**Our Case Number:** ABP-314724-22

**Re:** Railway (Metrolink - Estuary to Charlemont via Dublin Airport) Order [2022]  
Metrolink. Estuary through Swords, Dublin Airport, Ballymun, Glasnevin and City Centre to  
Charlemont, Co. Dublin

16<sup>th</sup> January 2023

**Ref: 314724**  
**App: Transport Infrastructure Ireland (TII)**  
**For: Railway (Metrolink - Estuary to Charlemont via Dublin Airport) Order**

TARA STATION

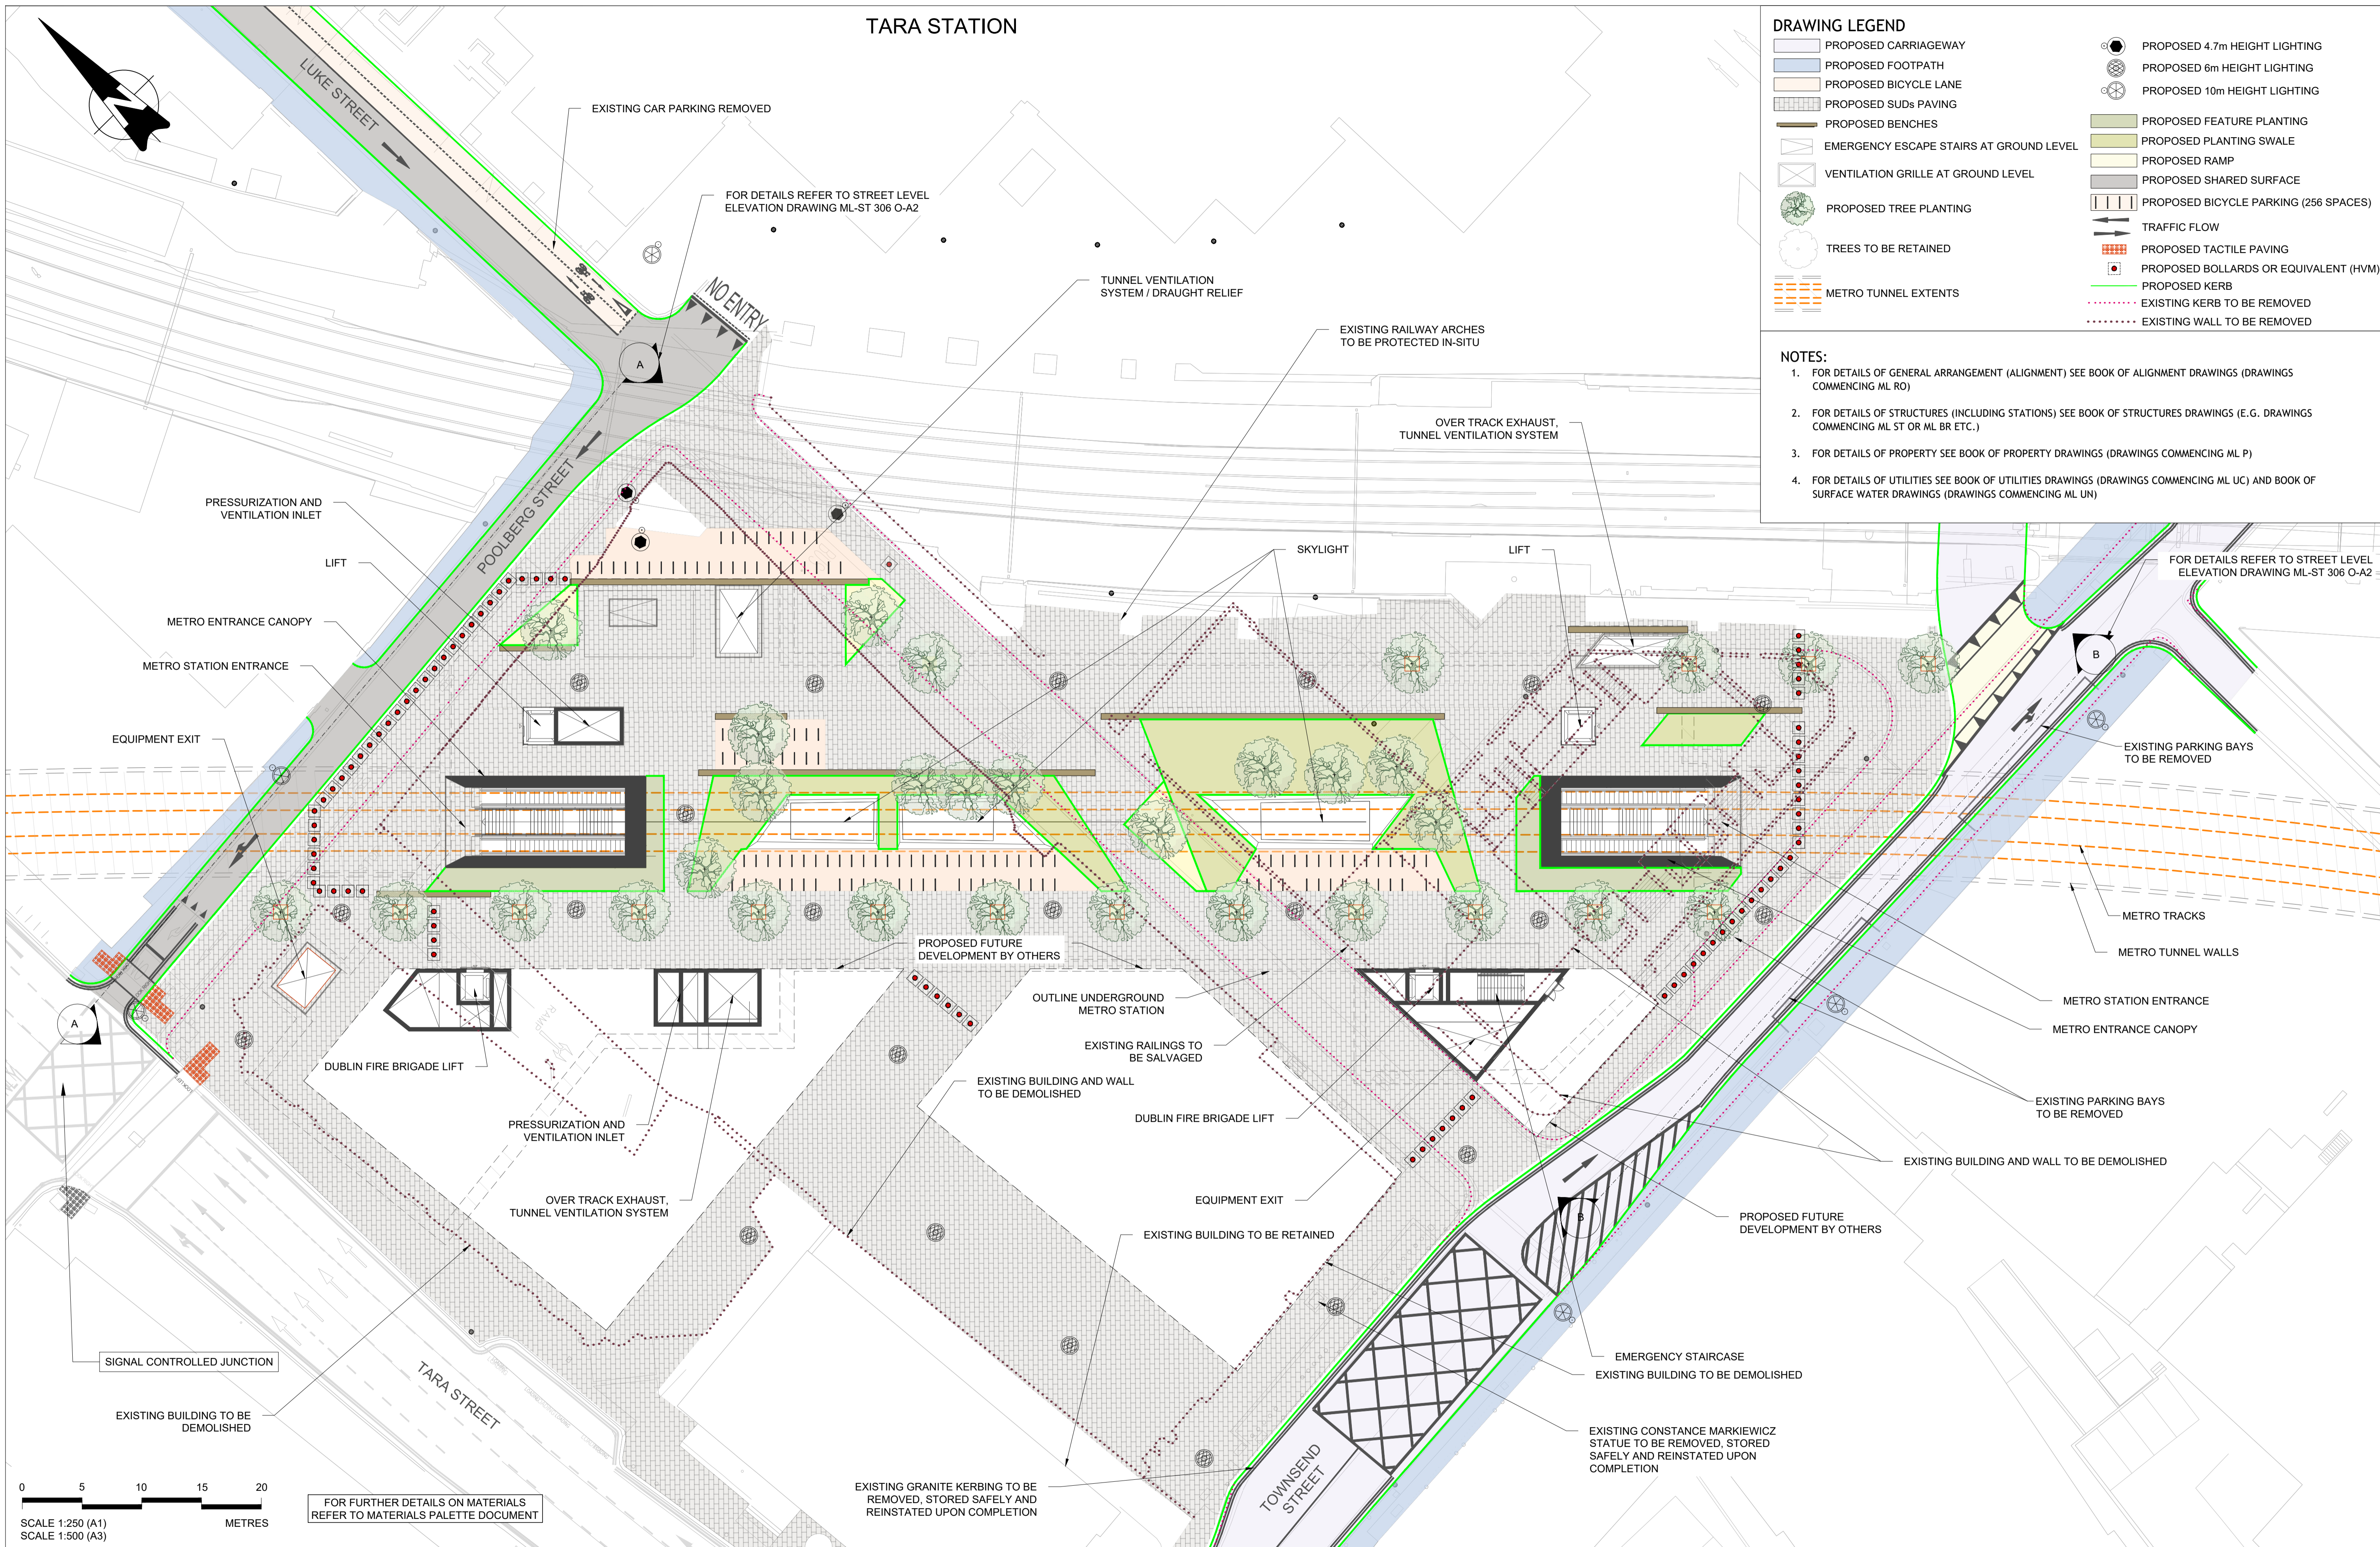
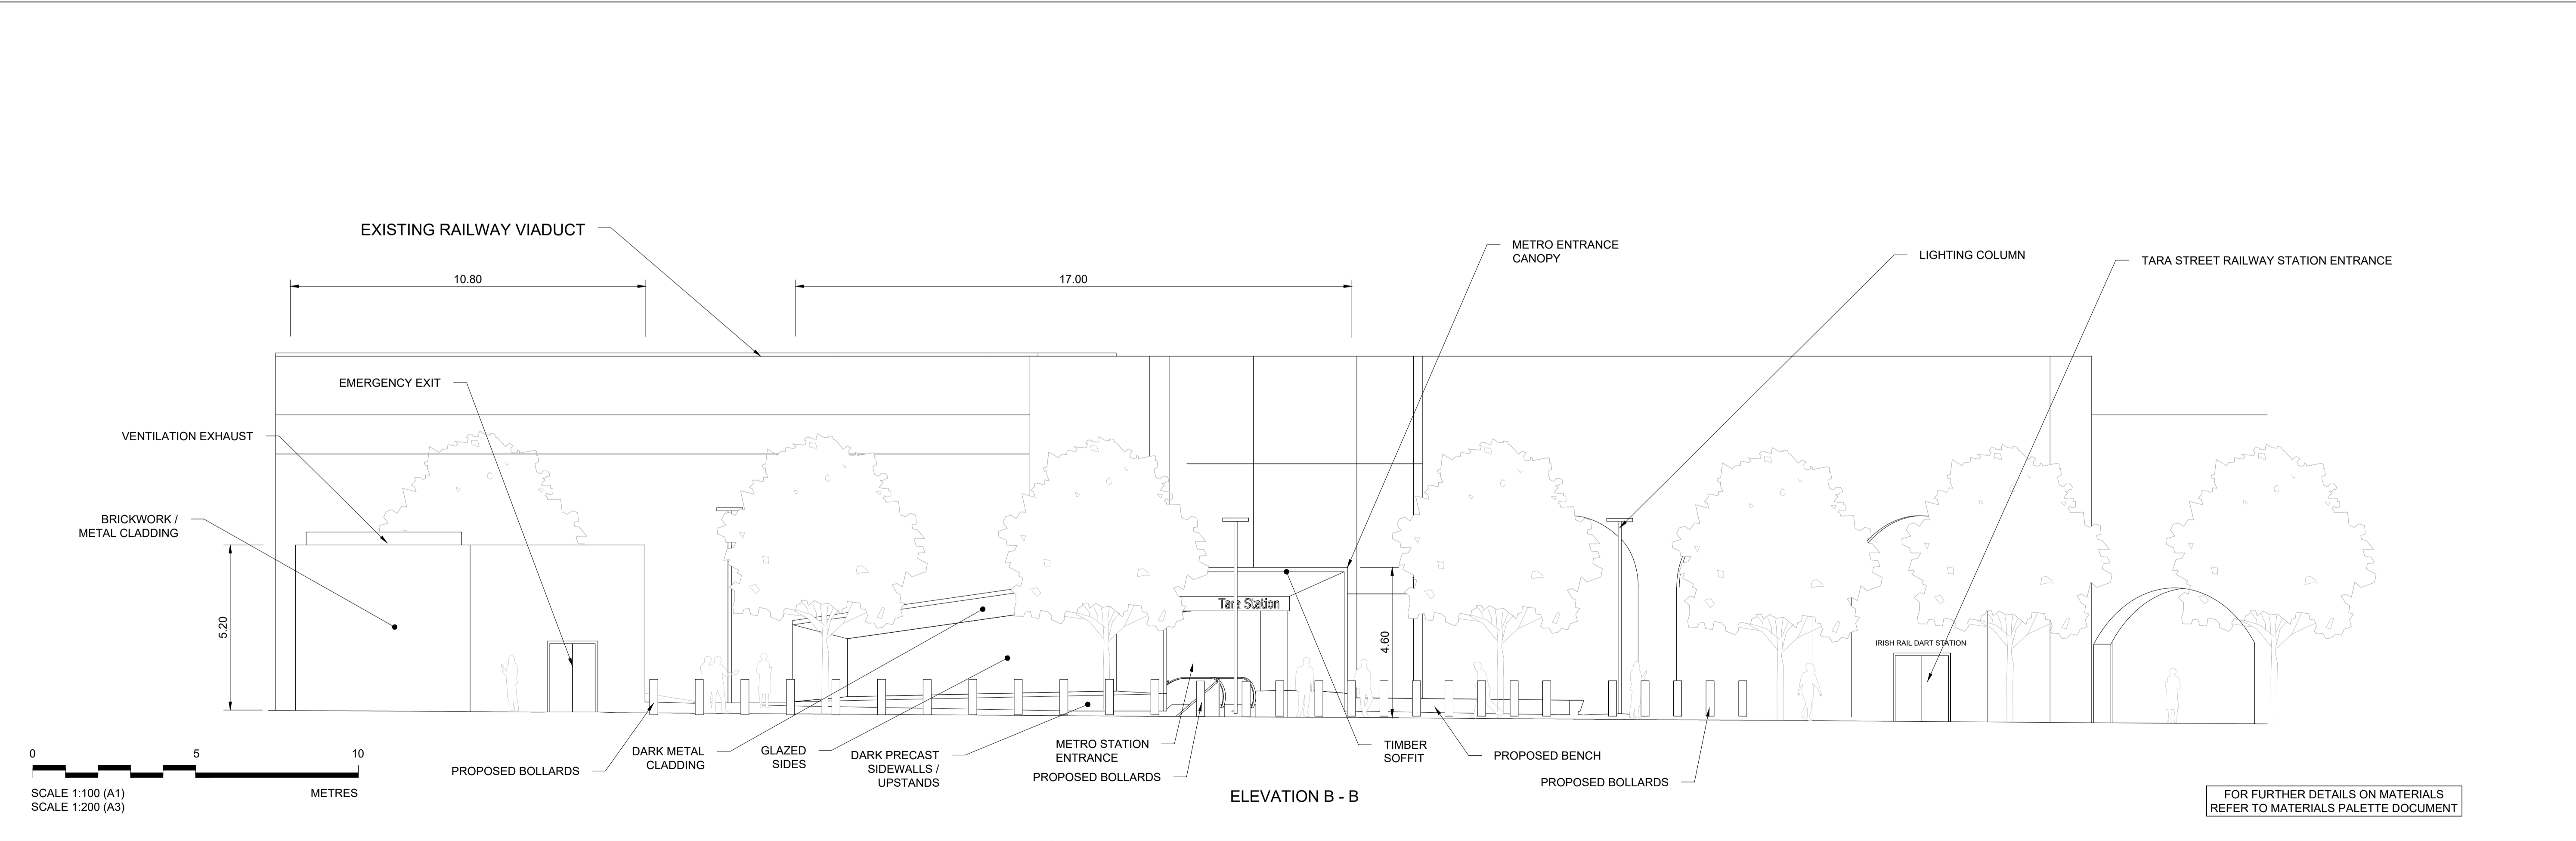
The remainder of our submission concerns options for the Tara Station due to considerations about the loss of community infrastructure and city centre residential accommodation.

The following sections of our submission will focus on engineering project risks and constraints for the selected option for Tara Station, which involves the demolishing the College Gate complex and the Markievicz Sport and Fitness Centre as well as two alternative design options, which would allow for its retention, if deemed appropriate.

Project risks for the base scheme, Option 0, include the compulsory purchase of the 70 apartments and eviction of the 150 residents in College Gate, which are in private ownership. This could also lead to unpredictable delays to the Metrolink Programme. Also impacted are commercial and residential properties, loss of community infrastructure, increased construction phase noise, vibration and dust due to building demolition.

TII state that for the above reasons Option 4 is not recommended. However, the listed Project Risks and Constraints have been successfully mitigated on other underground metro stations, in other jurisdictions, where similar construction techniques were utilised, where it was required to retain specific structures. We would suggest that Option 4 for Tara Station could be successfully implemented, once again here. We would therefore recommend that Option 4 be considered, if An Bord Pleanála deem that the College Gate building should be retained.

option 4, these Project Risks and Constraints have been successfully mitigated on other underground metro stations, elsewhere, and we would therefore recommend that Option 3A be considered, as an alternative to Option 4, if An Bord Pleanála deem that the College Gate building should be retained.

Should the subject project proceed as proposed in the application, it is submitted that the Markievicz Sport and Fitness Centre should be replaced elsewhere in the local area as part of the Metrolink project, given the Centre's importance as a community resource. It also submitted that further consideration is required regarding the loss of the substantial number of city centre residential units in the College Gate building.
